## **APP/2024/0379**

Proposal: Change of Use of Agricultural Land to Domestic Garden Ground (Class 9), and Erection of Domestic Garage

On Behalf Of: Roads Development - Buchan

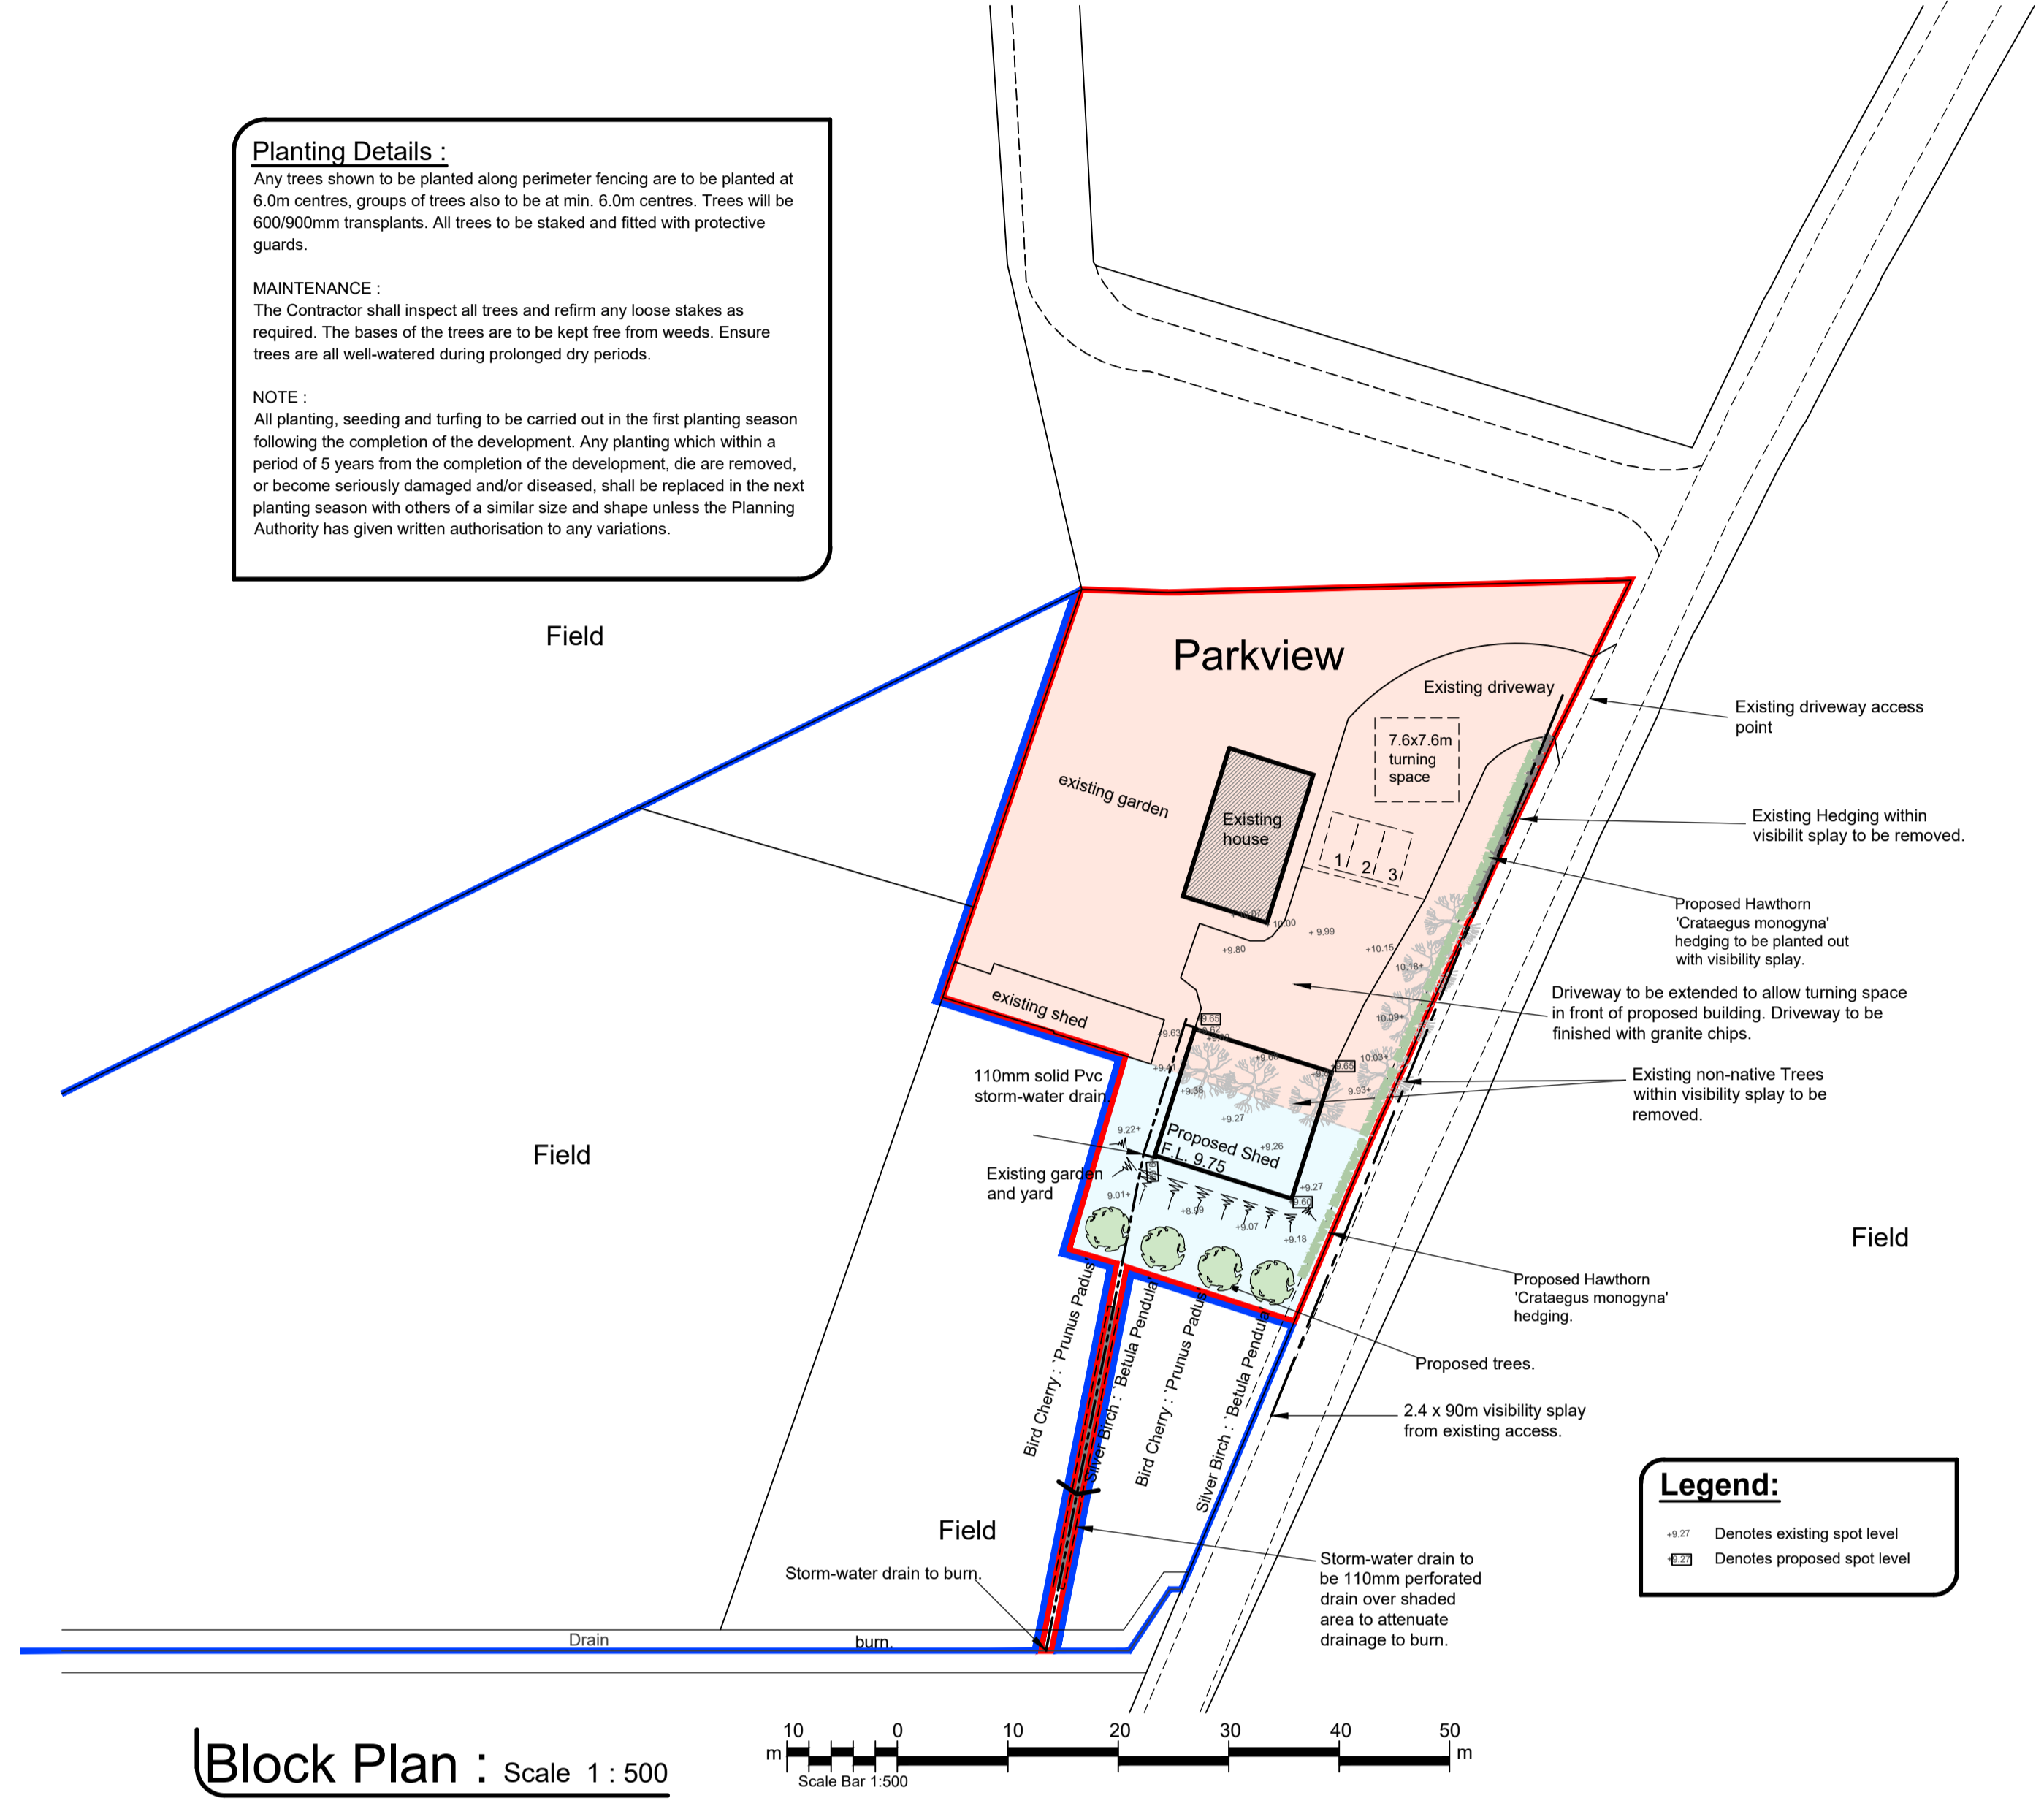
We would comment however that the visibility splay to the south of the access junction has been shown (2.4m by 90m we agree that this visibility splay length is appropriate) and note that the proposed new hedging / trees to the south are shown as being outside the visibility splay extent. It will be necessary to keep the vegetation to the south and north of the access trimmed back as required, to ensure that the required visibility splays of 2.4m by 90m in both directions are maintained in perpetuity.
